16 July 2019

File No: R/2016/32/C
Our Ref: 2019/335158

Barangaroo South Stage 1B Public Domain Works – SSD 7944 MOD 1

AVAILABLE SOIL VOLUME

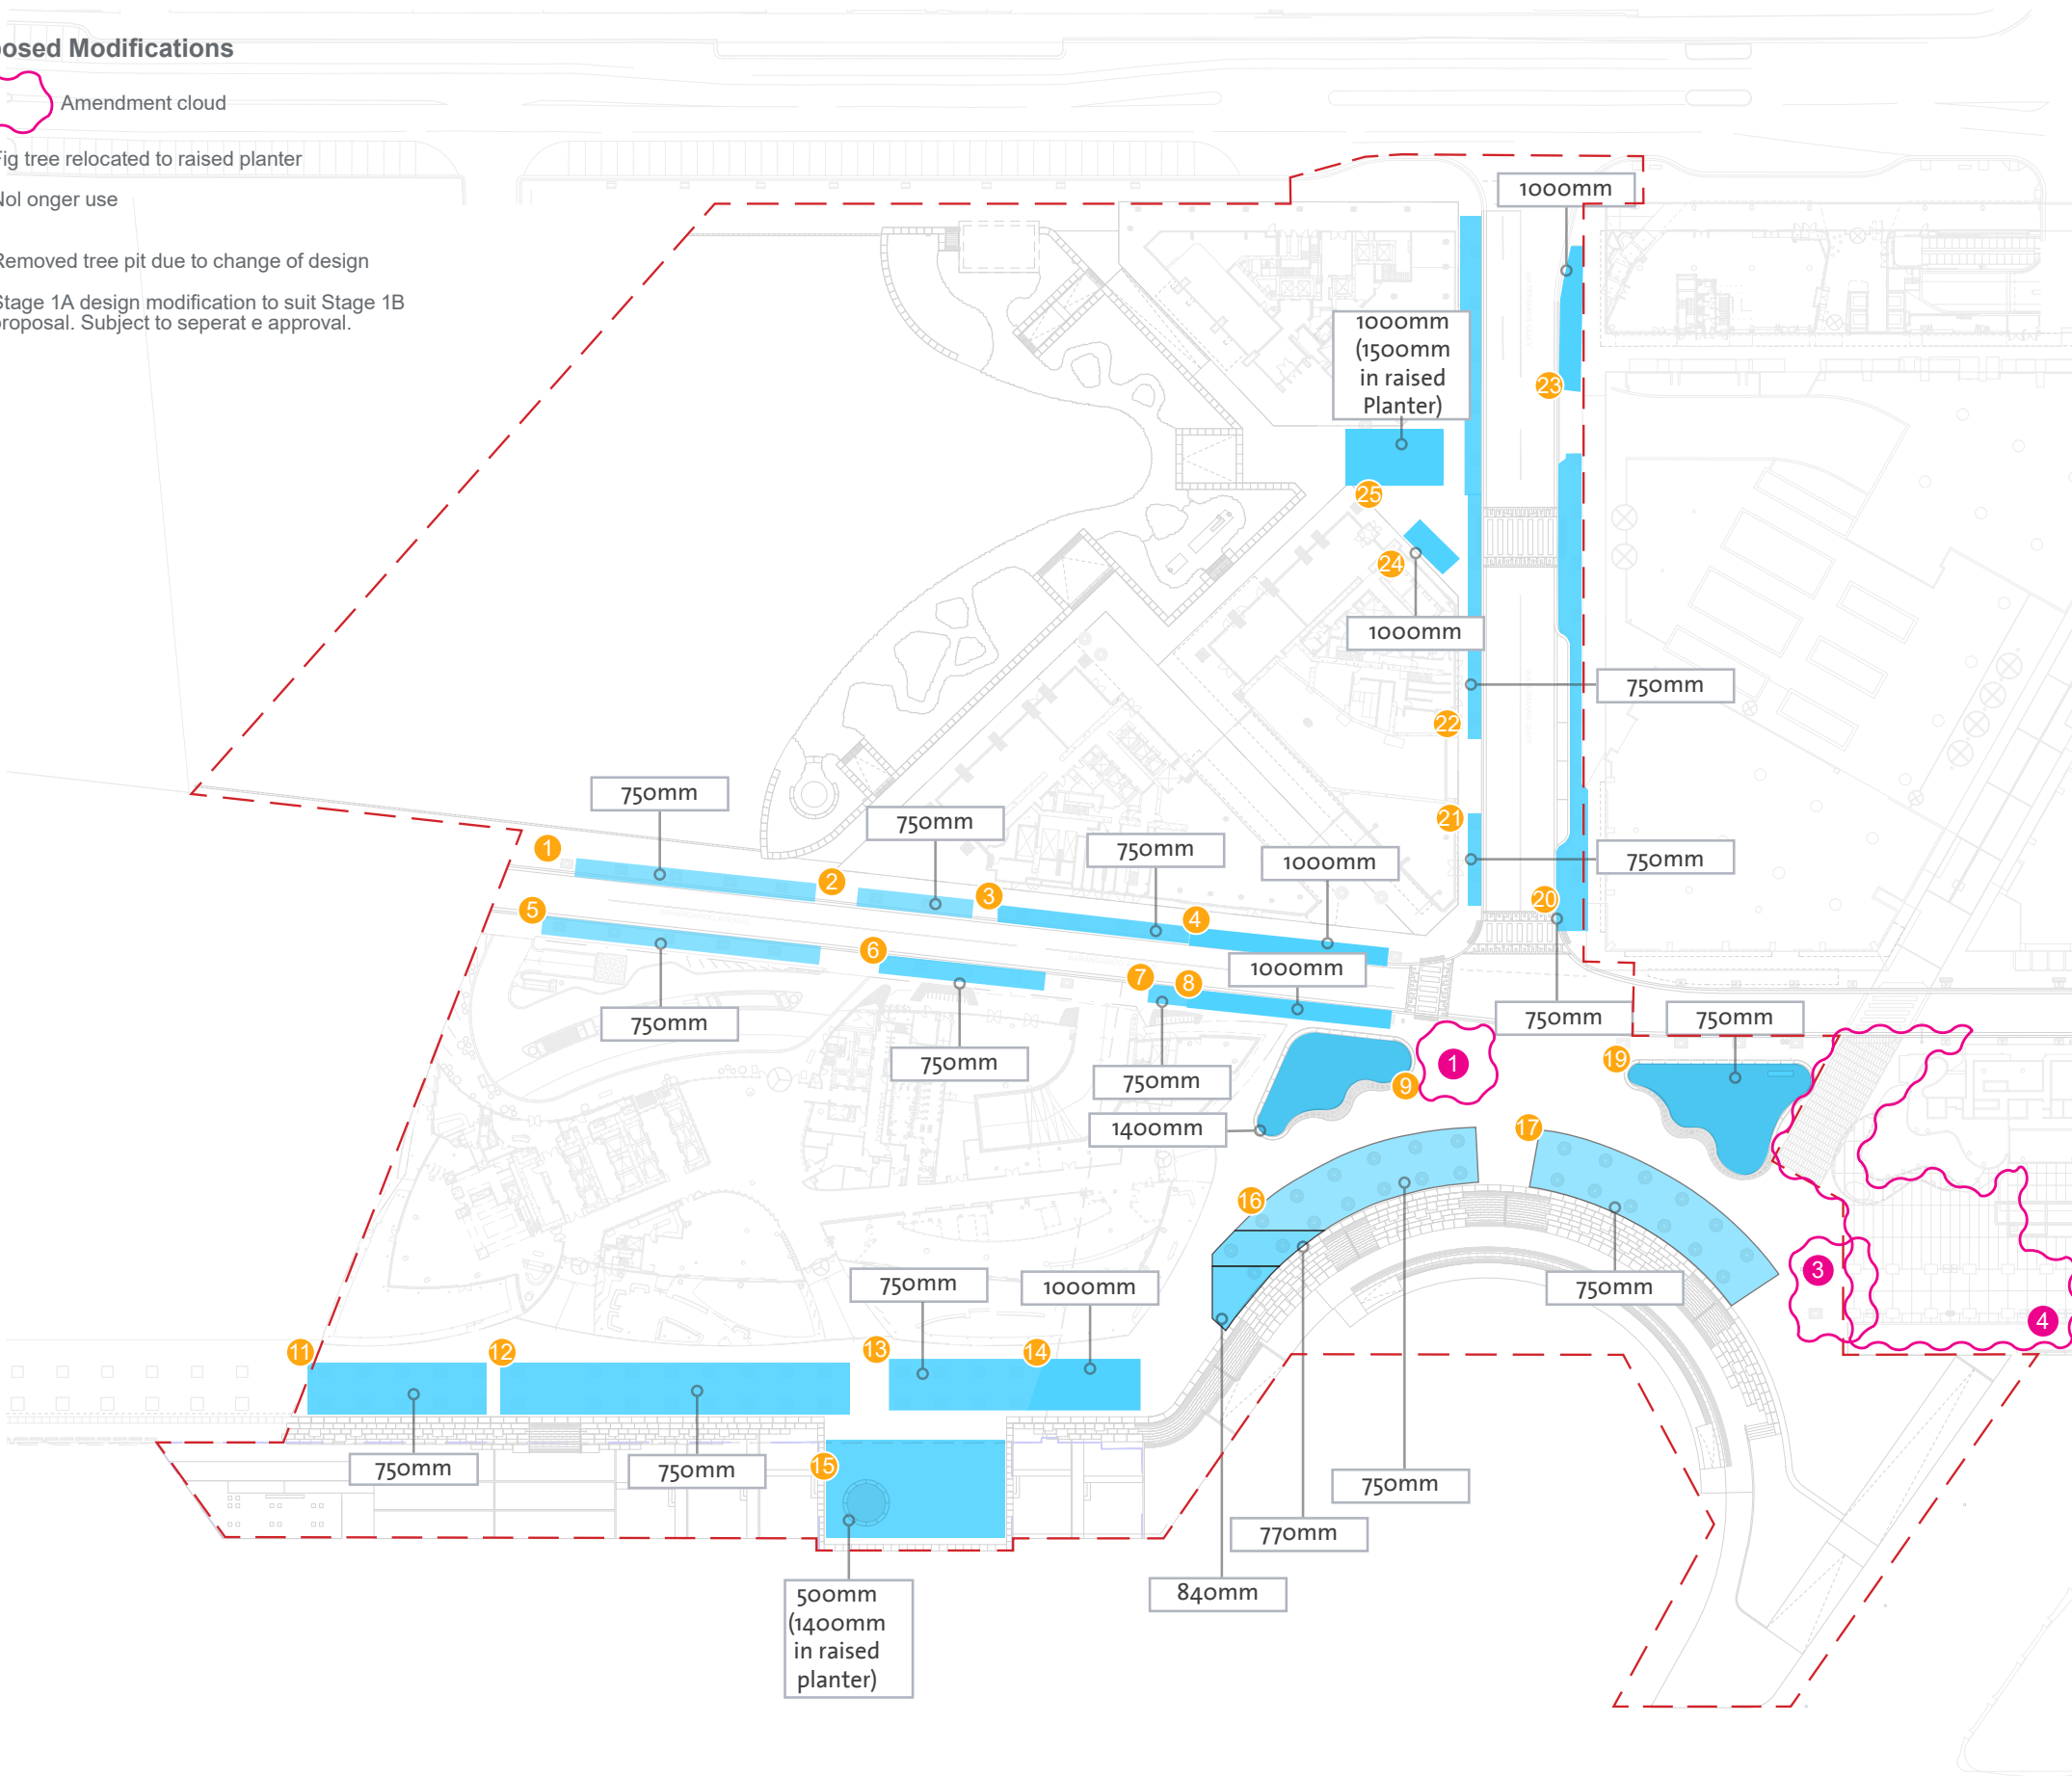
- The submitted plan sets out all new tree planting in the public domain in streets and waterfront quay. Only **4 out of 25 tree trenches** proposed achieve the minimum 1000mm depth required for trees on slab. Many trenches are only 750mm deep and some as little as 500mm.

HICKSON PARK SECTION B-B

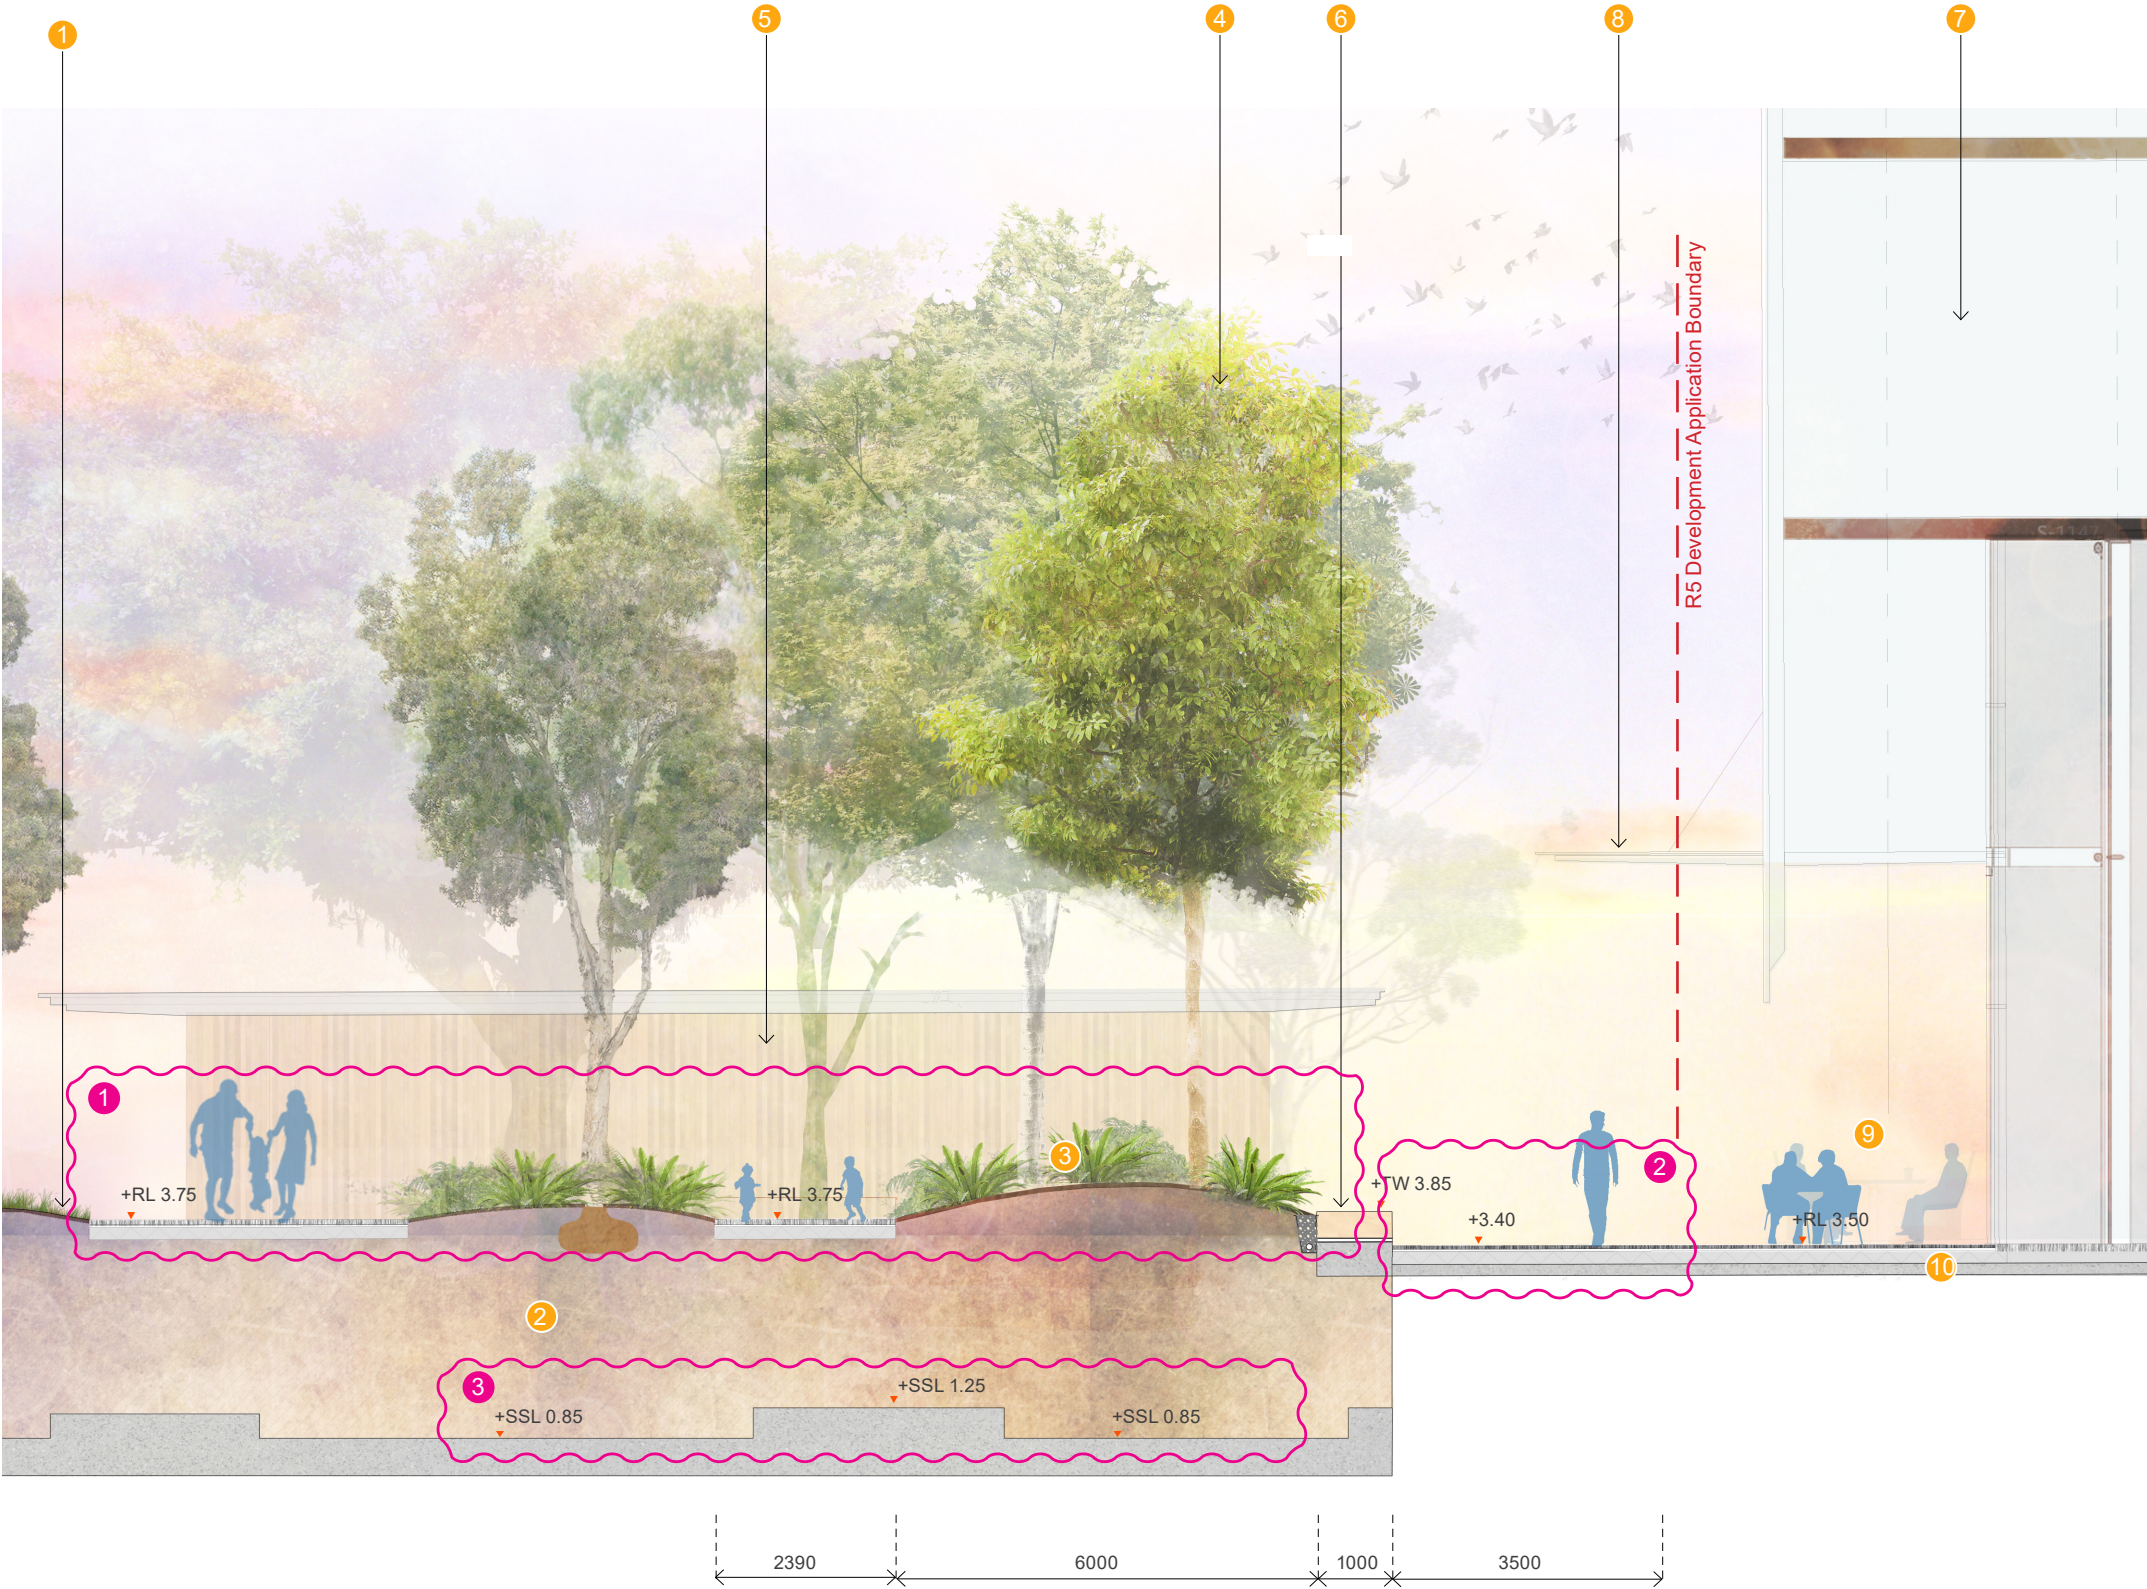
- According to the Hickson Park Sections, in areas the soil depth will be over 3000mm deep which will result in aerobic soil and is not good practice.
- The wall facing Barangaroo Avenue is up to 700mm higher than the adjacent public domain. The potential impact on required view corridors from Hickson Road to Darling Harbour if standing on Hickson Road (until 2023 when Hickson Road levels will be completed has not been tested and is unclear).

WATERMANS COVE DETAIL PLAN

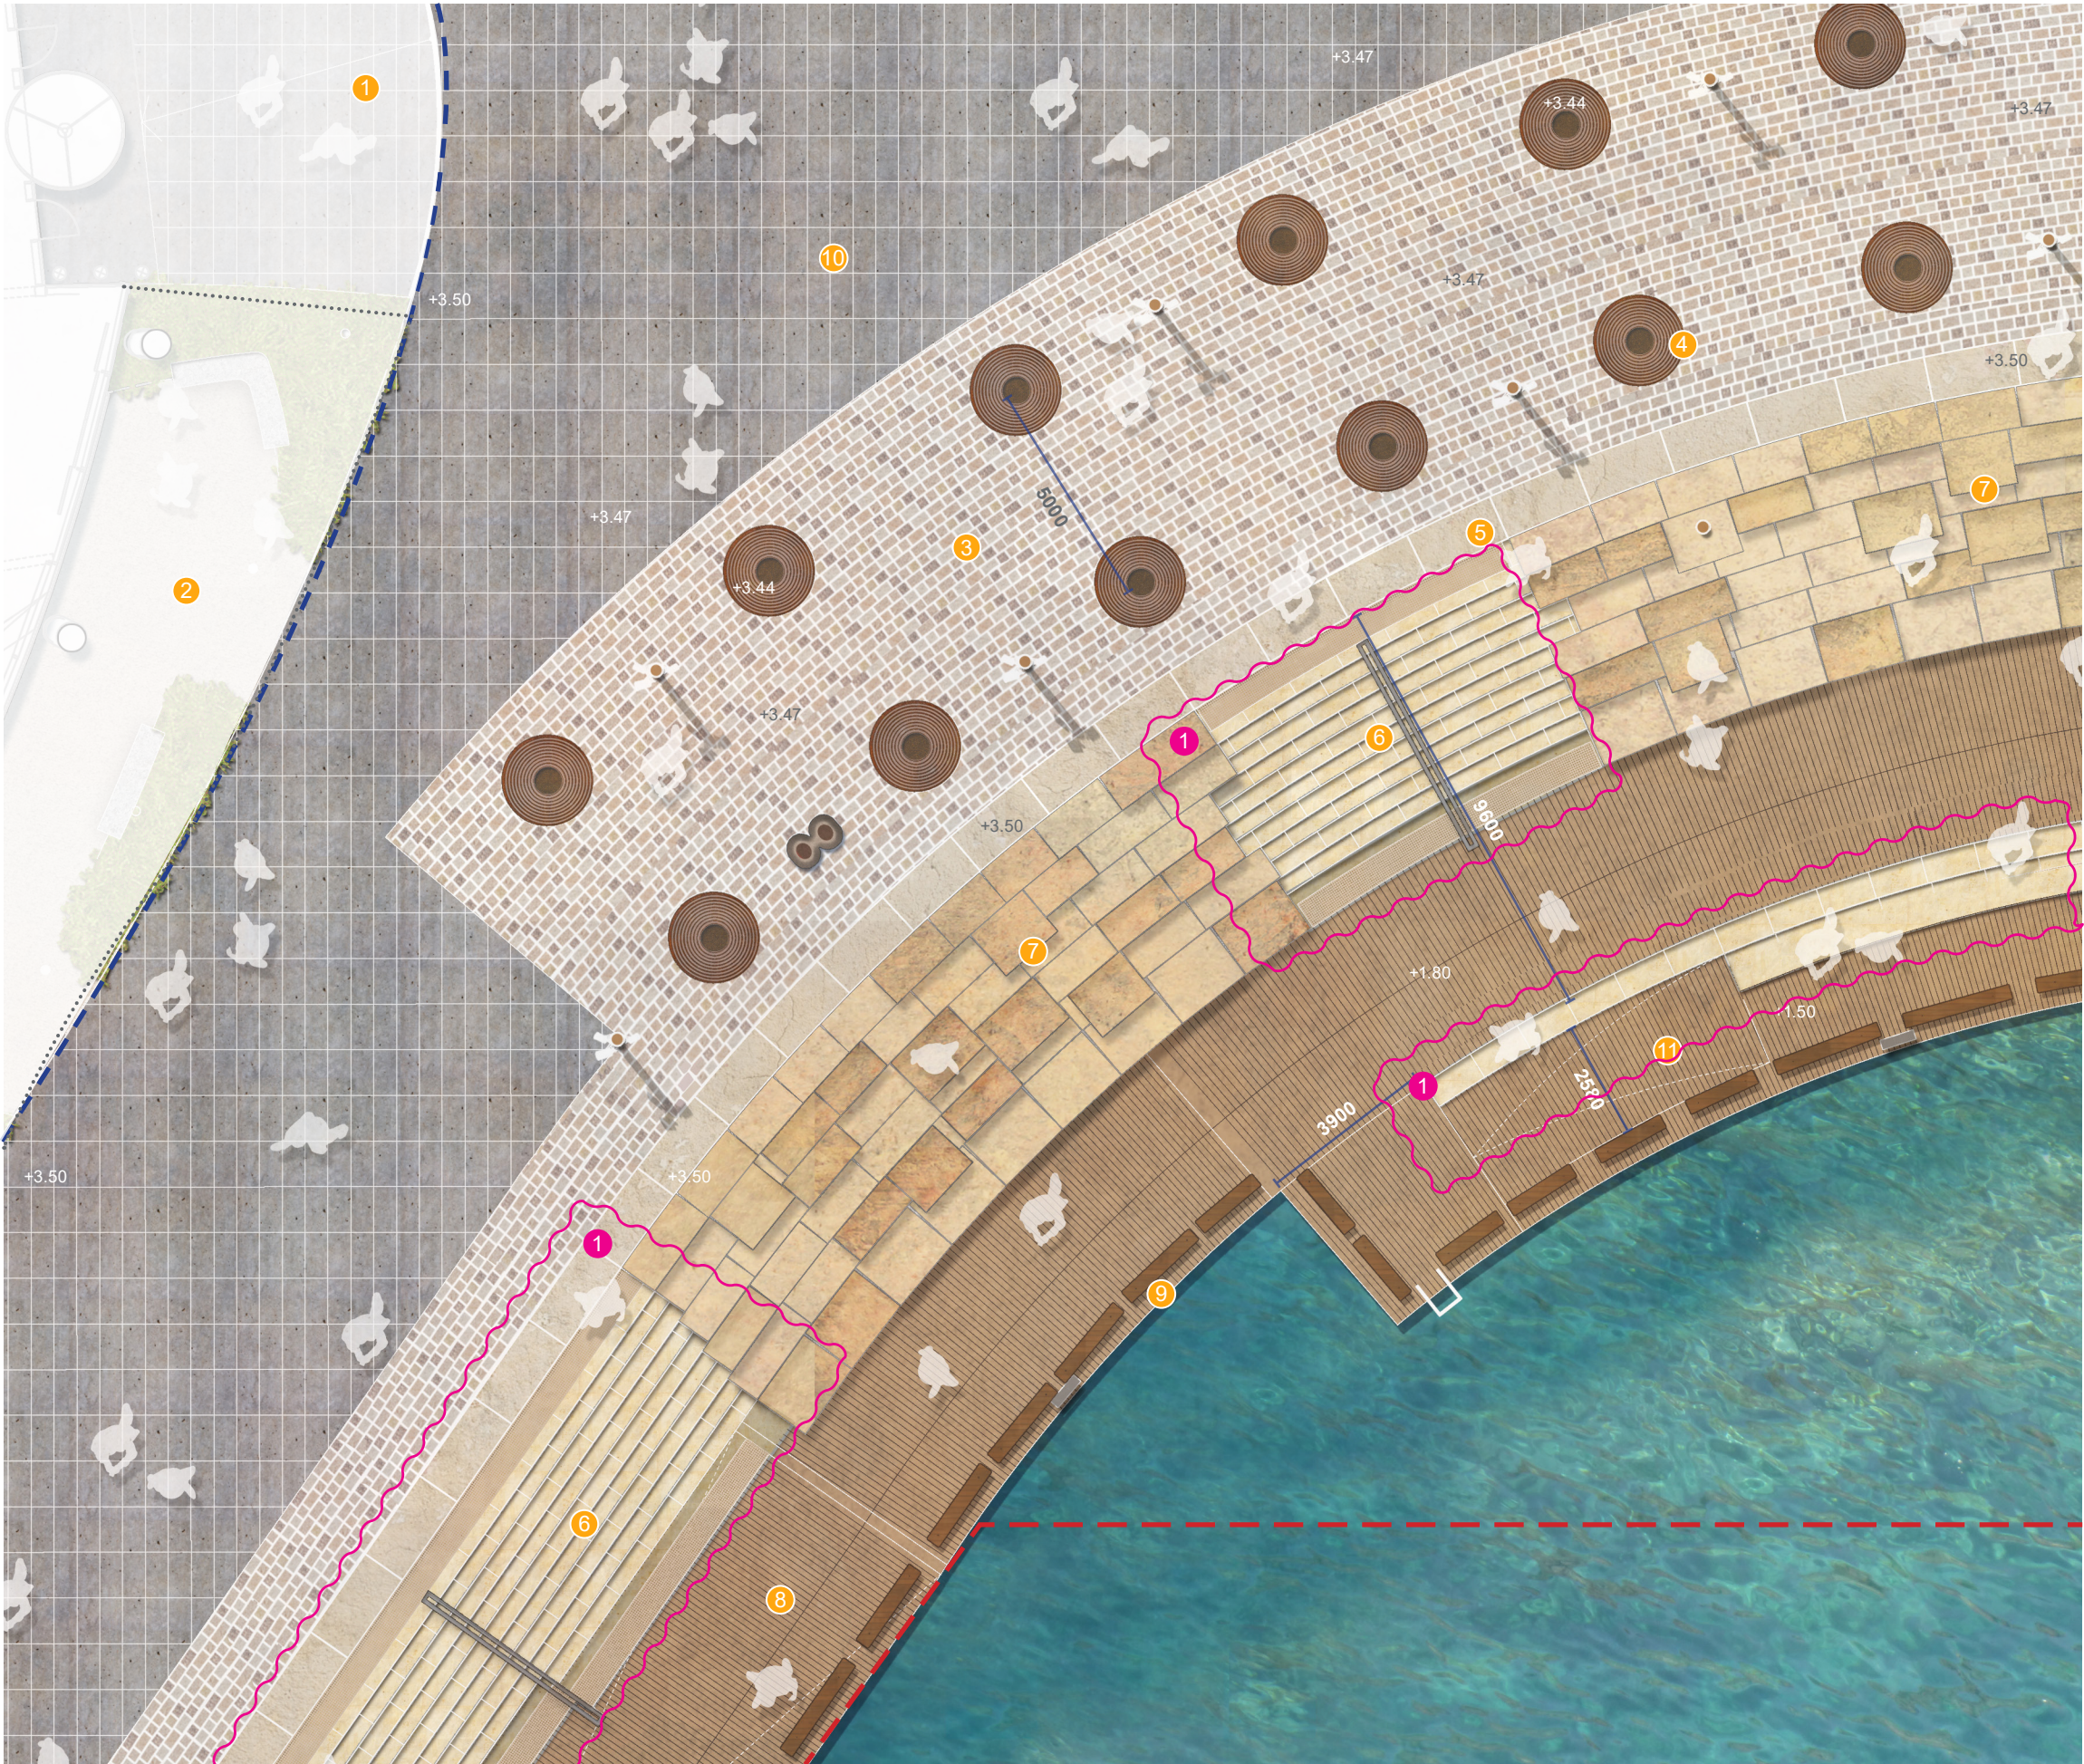
- The substitution of sandstone stairs with concrete, along Watermans Quay and Wulugul Walk and Boardwalk Park is a poor outcome for a high profile public space that will facilitate events and large public use year round.
